**Sheringham Shoal and Dudgeon Offshore Wind Farm Extension Project  
(EN010109): Written Statement**

## **Written Statement by National Highways**

**20 February 2023**

A47 Scarning Bridge. National Highways East Region advised initial assessment indicates bridge is not able to accommodate the proposed loads. Further clarification is being sought.

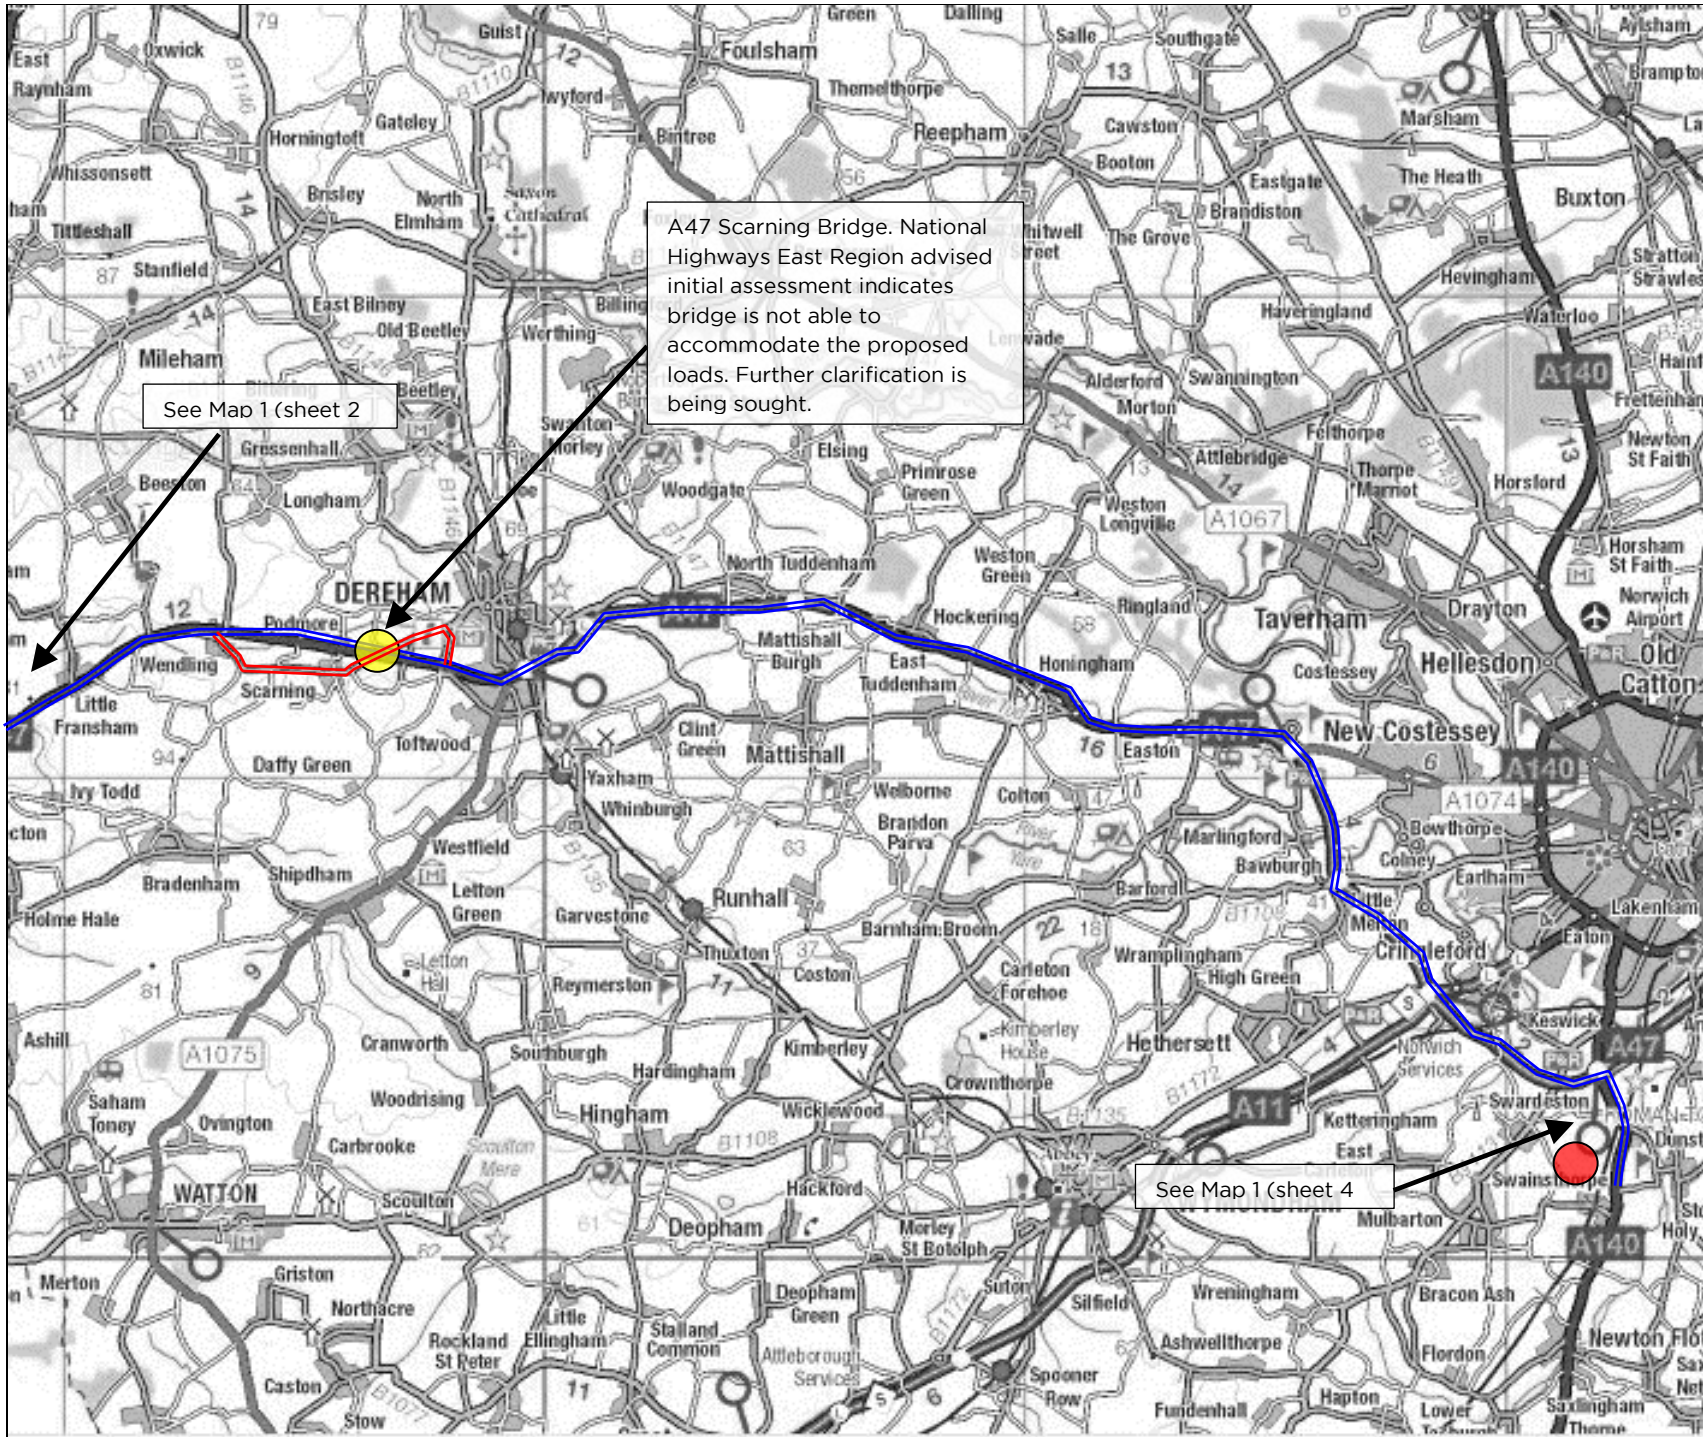
NH (responsible for the A47) have not been able to structurally confirm the route for abnormal indivisible loads [APP-270] as there are two structures of concern (Scarning Bridge and a culvert located between Kings Lynn and Swaffham). It is set out that NH is still reviewing these structures to establish if the route can be cleared. What is the up-to-date position on this?

Response: Discussions are taking place between the Applicant's transport consultant and relevant National Highways teams. It is expected that an update will be provided by Deadline 3.
